Re: Permit 2005-027

Project: Belady Garage; Project address: 7627 78th Ave NE, Mercer Island, 98040

This letter is a follow-up to questions regarding the Intake Comments CST dated 6/23/2020. Particular comments are addressed below. Changes as request in the comments are identified by Delta 1 on the drawing sheets.

SOUTH ELEVATION
1/4" = 1'-0"

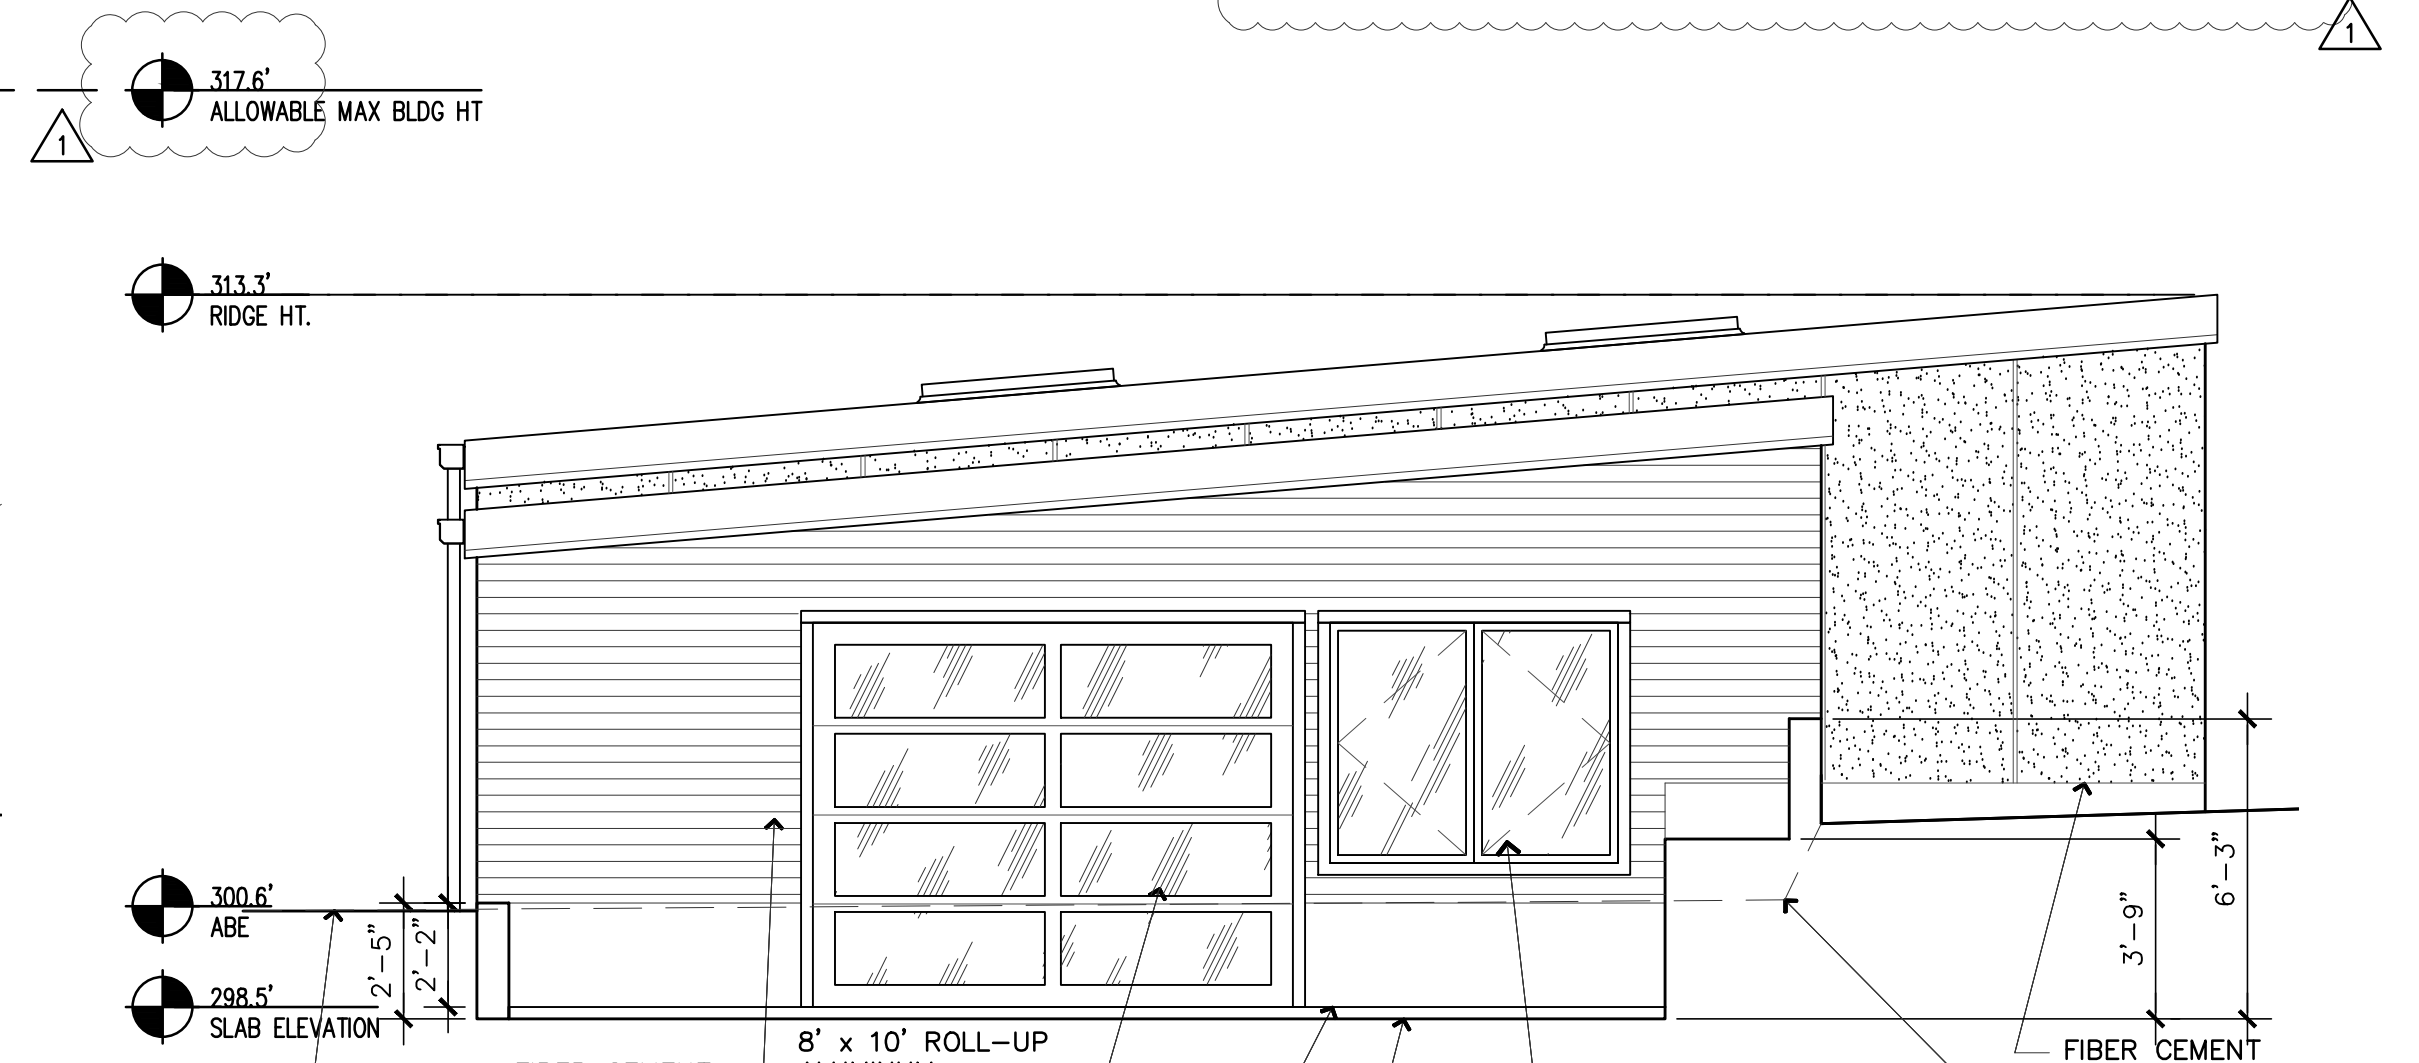
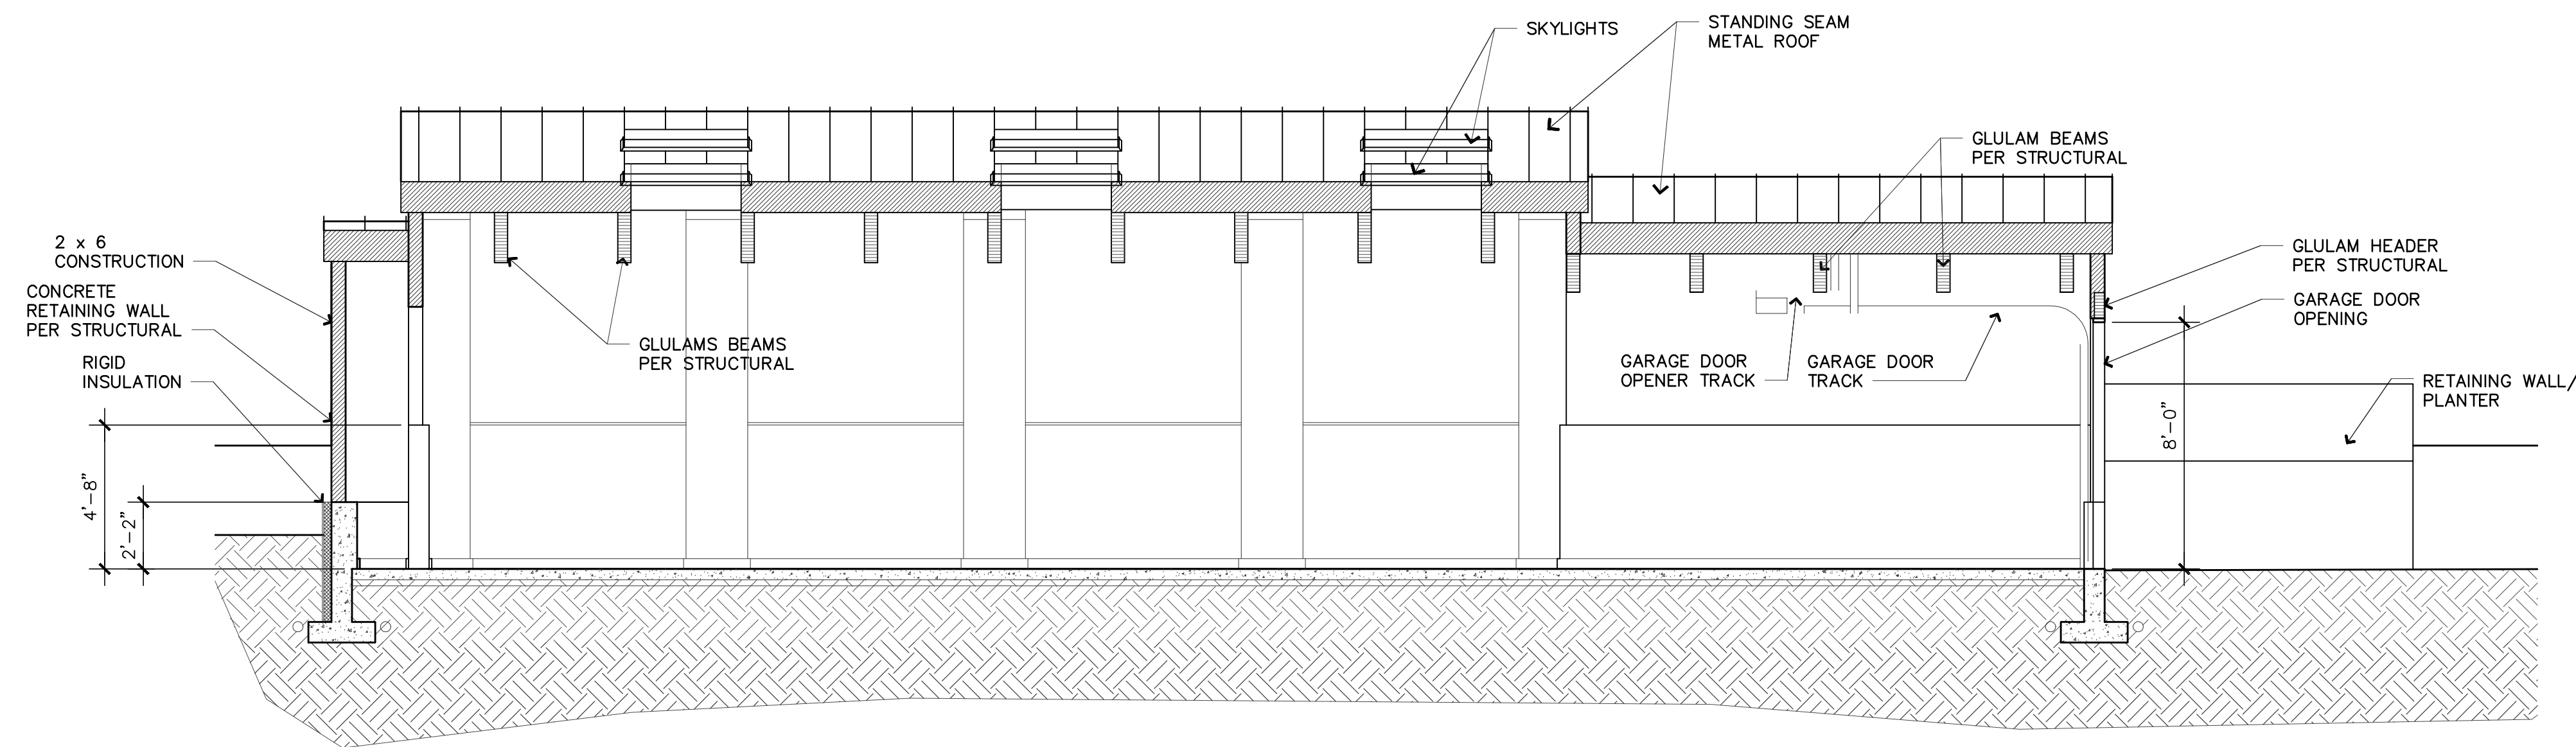
> Elevation Drawings. Refer to sheet A4.01. The corrected items are identified by Delta 1 symbol, including the following; Indicate buildings and proposed height; Indicate existing grade and finish grade; Indicate average building elevations (ABE) on all elevations drawings with ABE calculations table; Height of appurtenances above max height (none); Indicated allowable building height on all elevation drawings.

ABE table and dimensions, existing and finish grade, proposed building height and max building height are added to the elevation drawings. Refer to sheet A4.01.
